from
**Southern
Water**

Our ref
PLAN-037152

Proposal: Approval of reserved matters (appearance, landscaping, layout and scale) following the grant of Y/91/17/OUT for 250 No. dwellings with associated parking, road/footway/ cycleway provision, open space, landscaping, surface water attenuation & ancillary works.

Site: Y/152/20/RES: - Land at Bilsham Road, Yapton, BN18 0LF.

drawing title
General Arrangement Plan

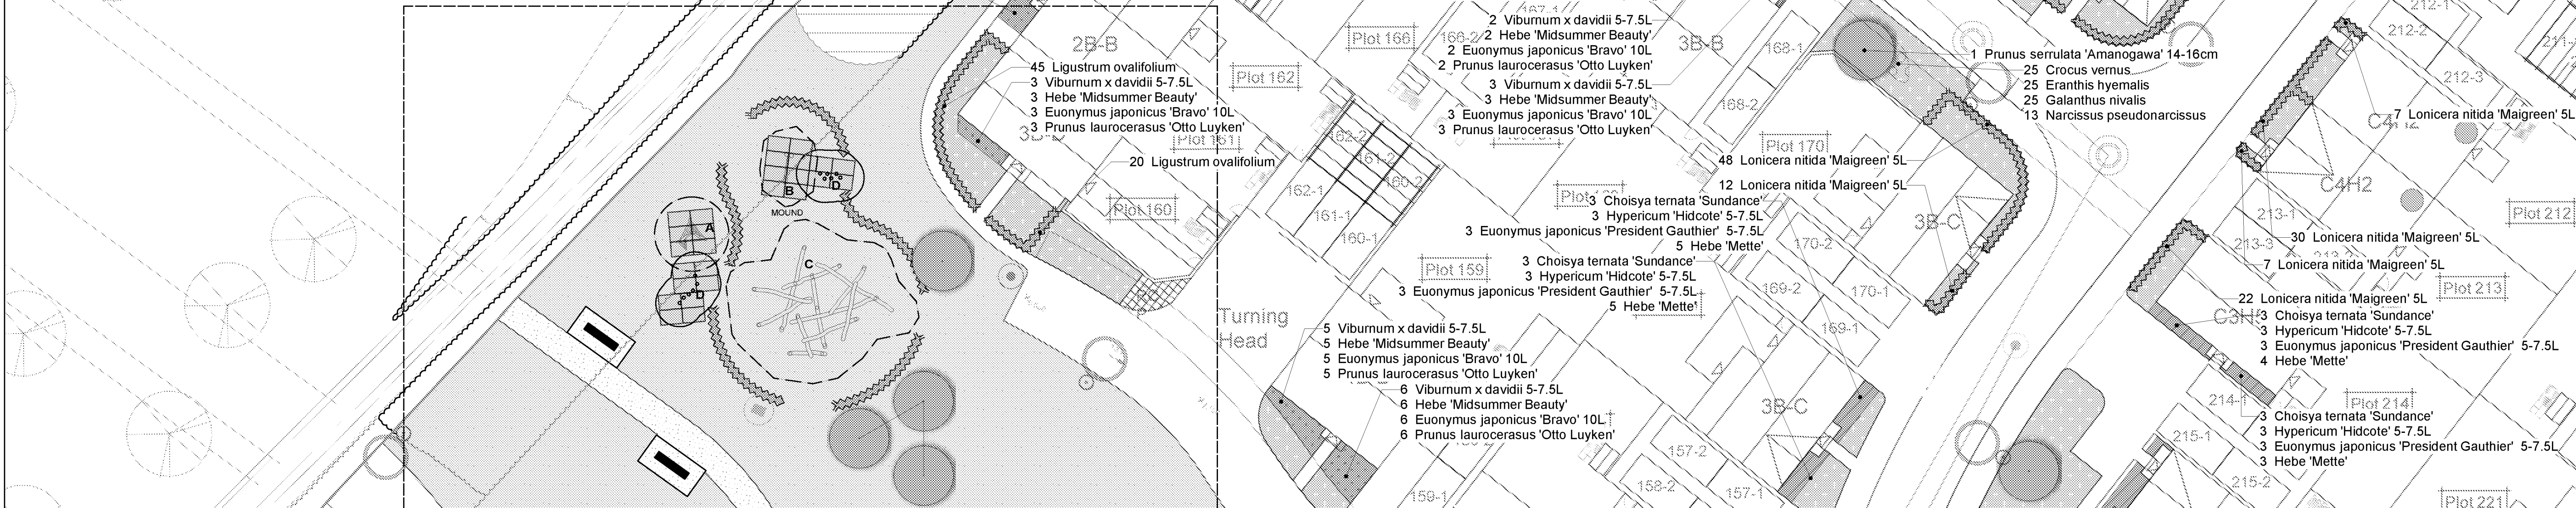
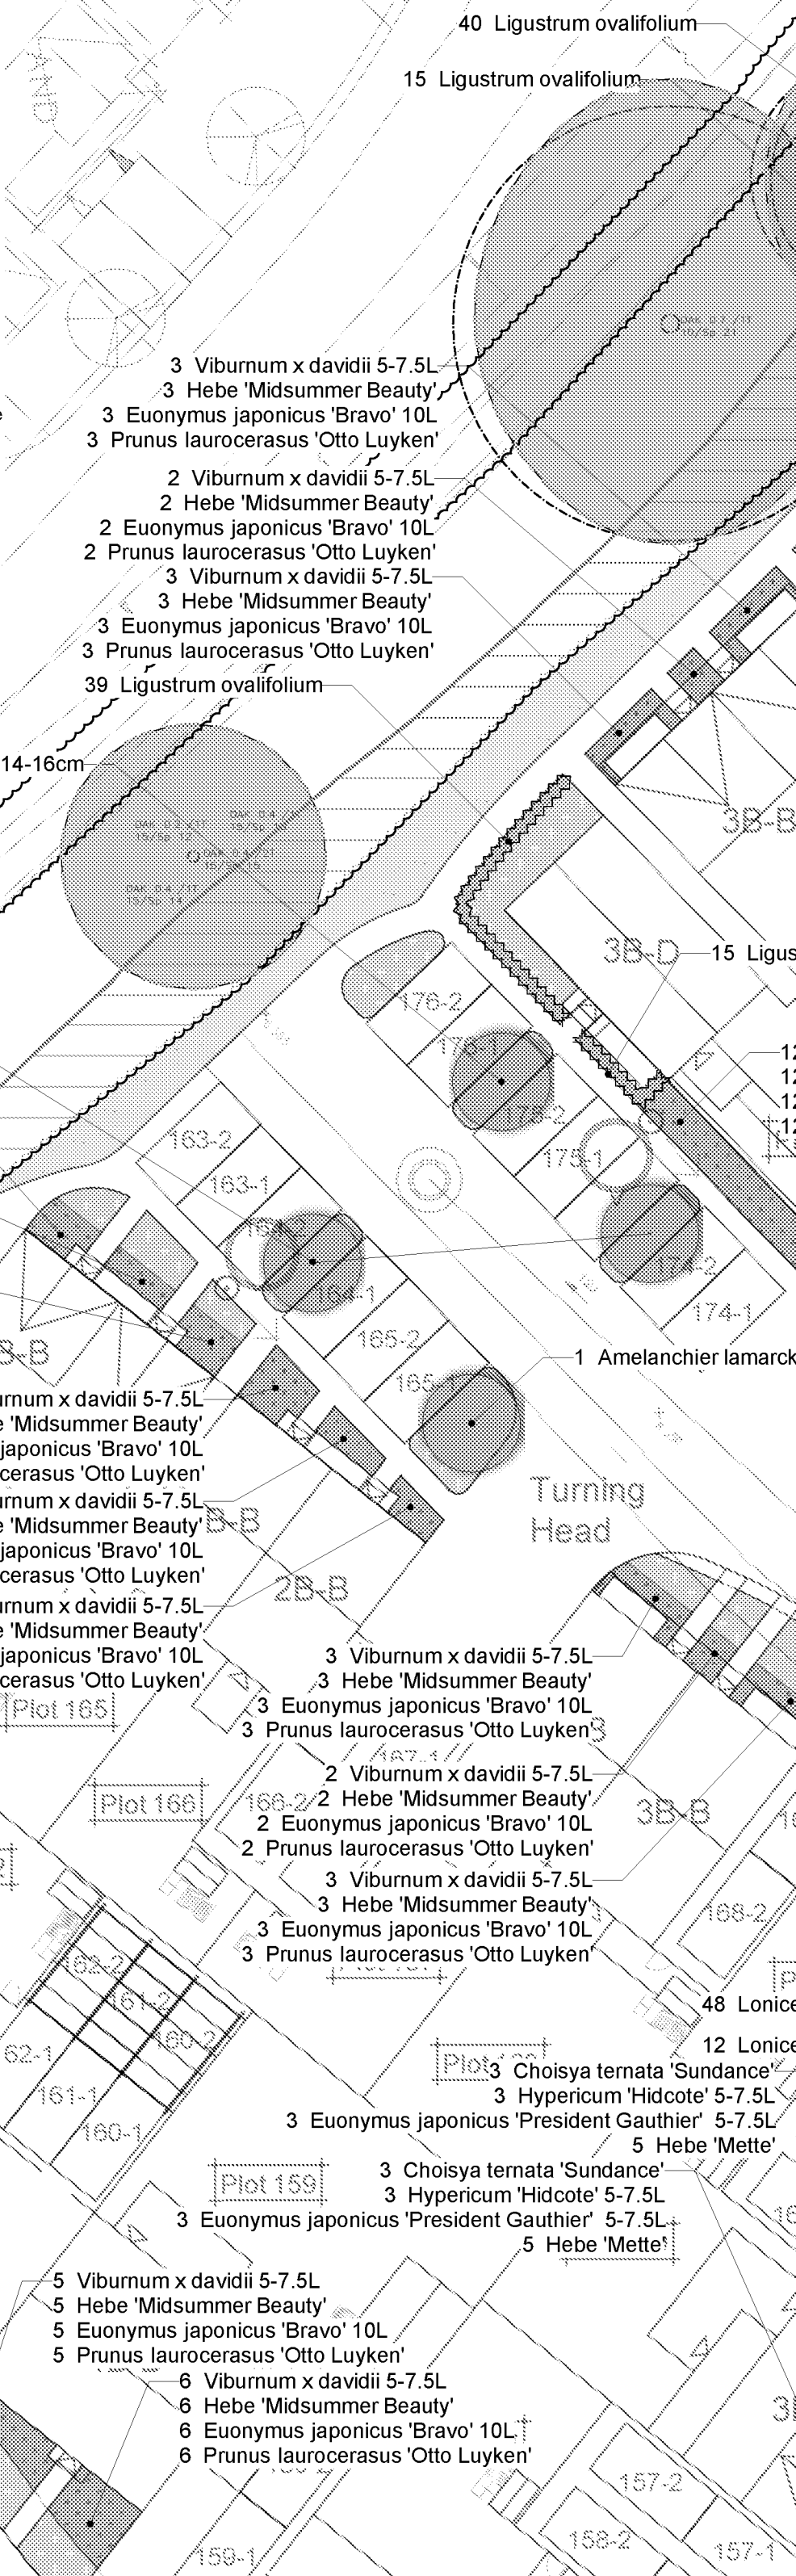
The submitted drawing indicates tree planting close to public surface water sewer.

We have restrictions on the proposed tree planting adjacent to Southern Water sewers, rising mains or water mains and any such proposed assets in the vicinity of existing planting. Reference should be made to Southern Water's publication "A Guide to Tree Planting near water Mains and Sewers" (southernwater.co.uk/media/3027/ds-tree-planting-guide.pdf) and the Sewerage Sector Guidance (water.org.uk/sewerage-sector-guidance-approved-documents) with regards to any landscaping proposals and our restrictions and maintenance of tree planting adjacent to sewers, rising mains and water mains.
